From: Michael Eastham <Michael.Eastham@arun.gov.uk>
Sent: 02 March 2020 12:12
To: Planning.Responses <Planning.Responses@arun.gov.uk>
Subject: FW: Planning Consultation on BE/15/20/DOC

Application ref: BE/15/20/DOC

Description: Approval of details reserved by condition imposed under hybrid application ref BE/135/18/PL relating to Full Approval Condition Nos 3 - materials and external finishes of buildings in Phase 1, 4 - external lighting for any unit except Unit 2, **10 - hard and soft landscaping**, 19 - badger survey, 21 - CCTV strategy Units 4-9, 30 - security fencing between Unit 8 & Units 6 & 7 and around Unit 9, 44 - 2.0m high bunding and 46 - existing & proposed ground levels, proposed finished floor levels, levels of paths & parking and proposed completed height of development.

Location: Land At Salt Box West Of Shripney Road Bognor Regis PO22 9NW

Full application Condition 10 - Units 4,5,6,7 & 8 Hard & Soft Landscaping

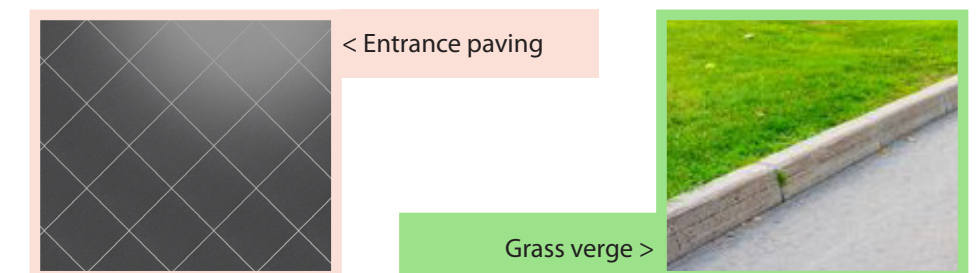
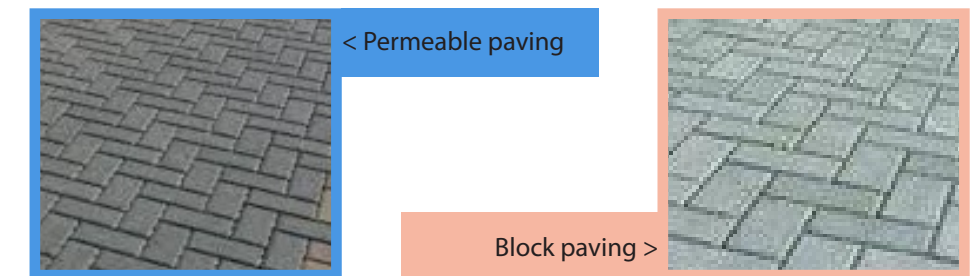
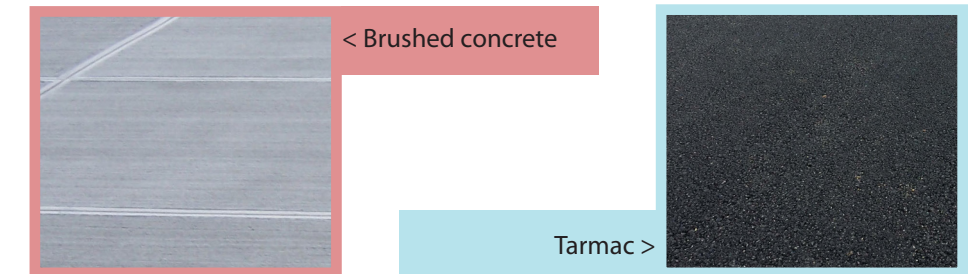
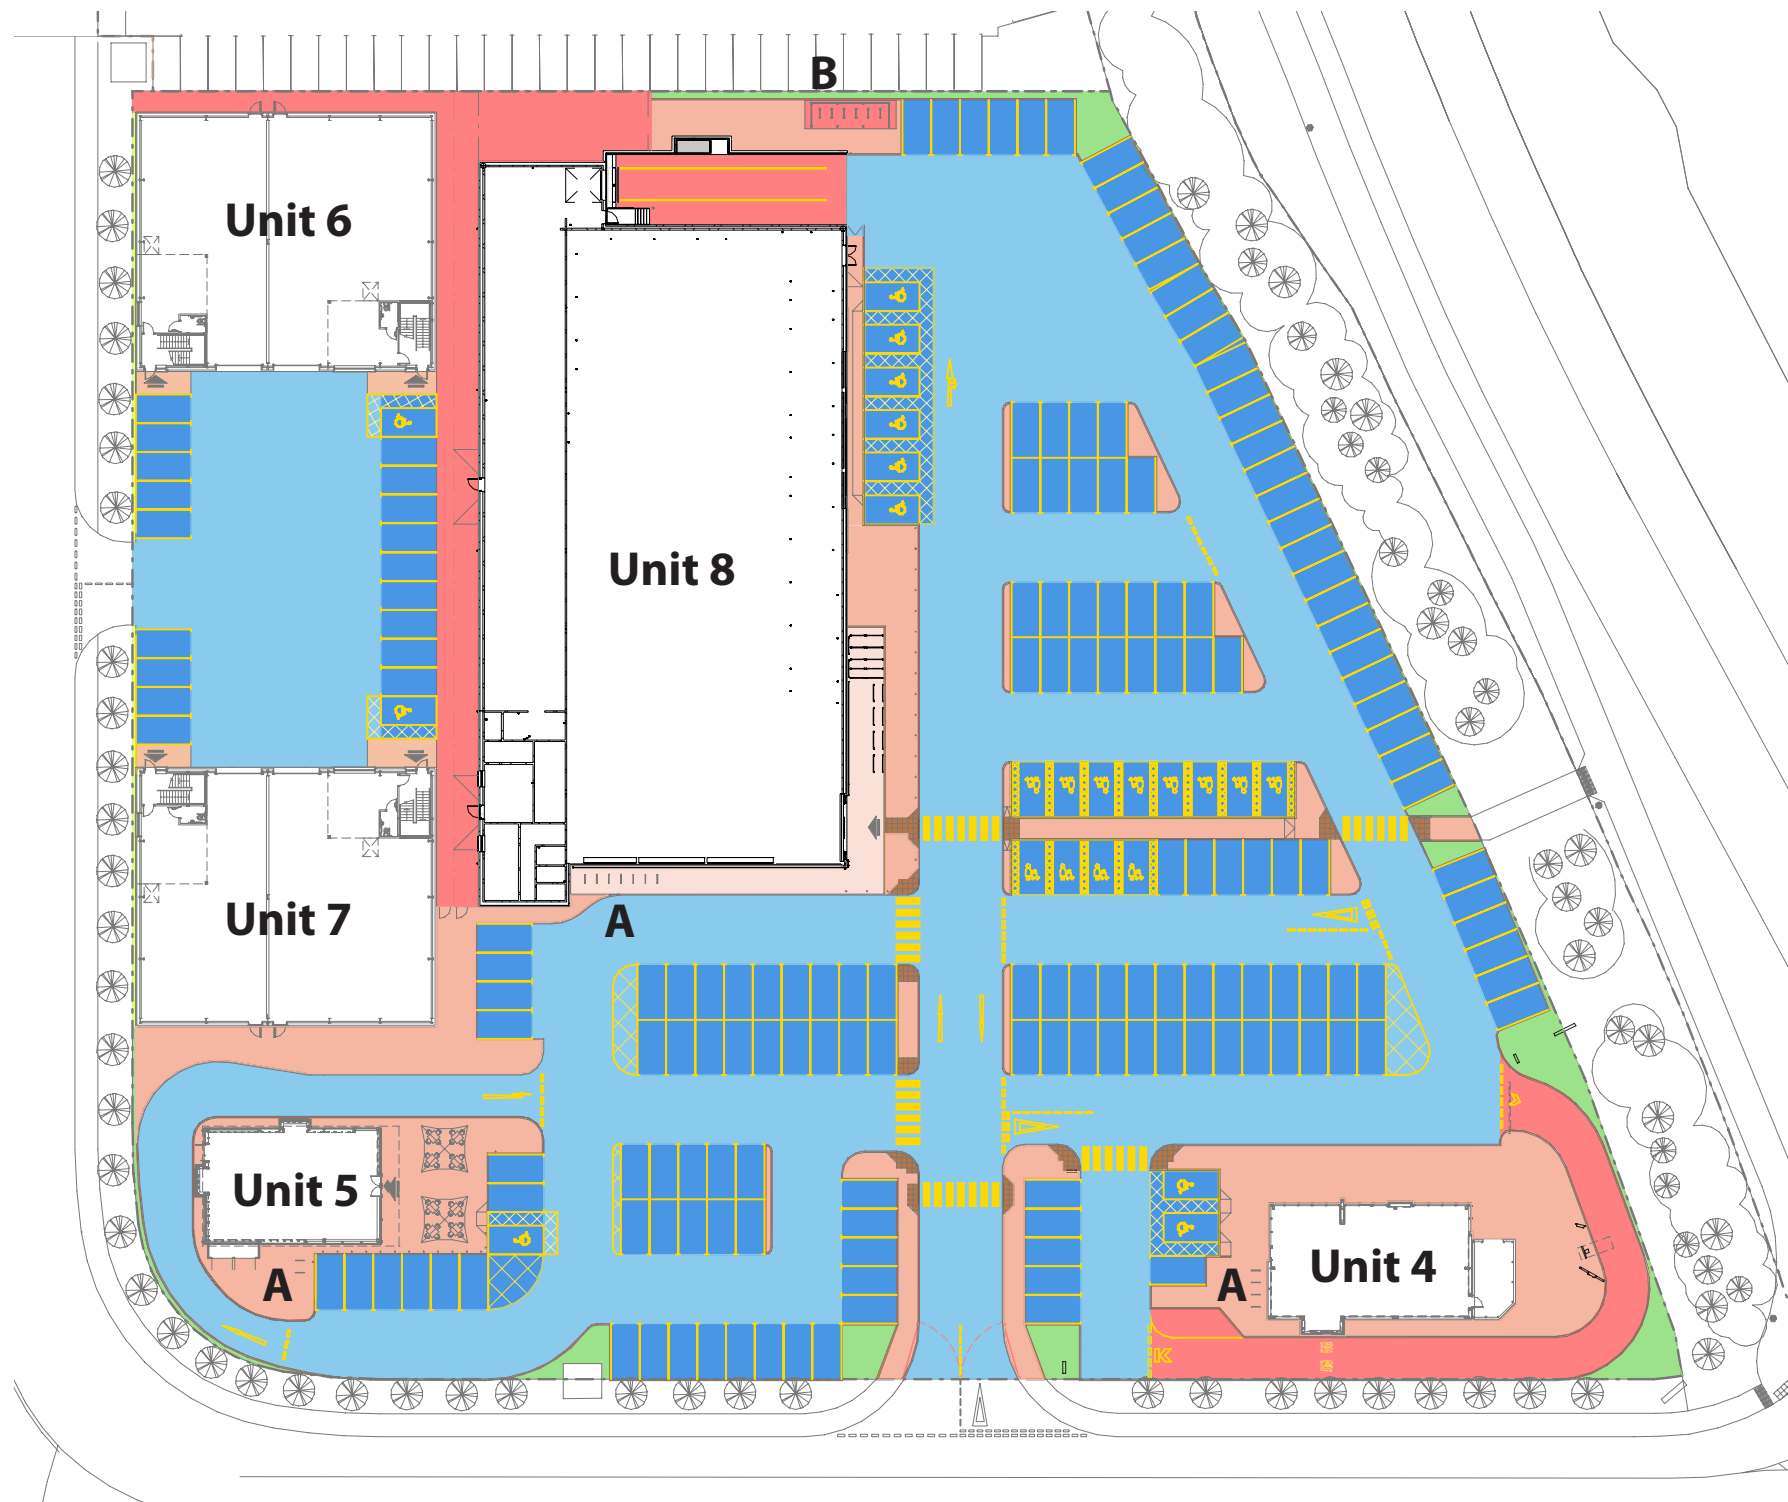
With regard to their query about the soft landscaping around unit 4-8, there is only grass verge and no other planting within this area, so I'm not sure what more detail we can provide. Can you please confirm? Is there something specific they want to know?

Following submission of Landscape proposals Saltbox Site Northern Bund Cross Section Detail dwg no 5920.CSD.10.0 Rec C I would advise that this drawing contains insufficient detail regarding plant species, actual quantities, planting densities and size at time of planting. Detail also submitted in Units 4,5,6,7,8 hard and soft landscaping dwg also contains insufficient soft landscaping detail.

Re soft landscaping around unit 4-8, there is only grass verge and no other planting within this area; happy with this explanation and therefore no further detail required.
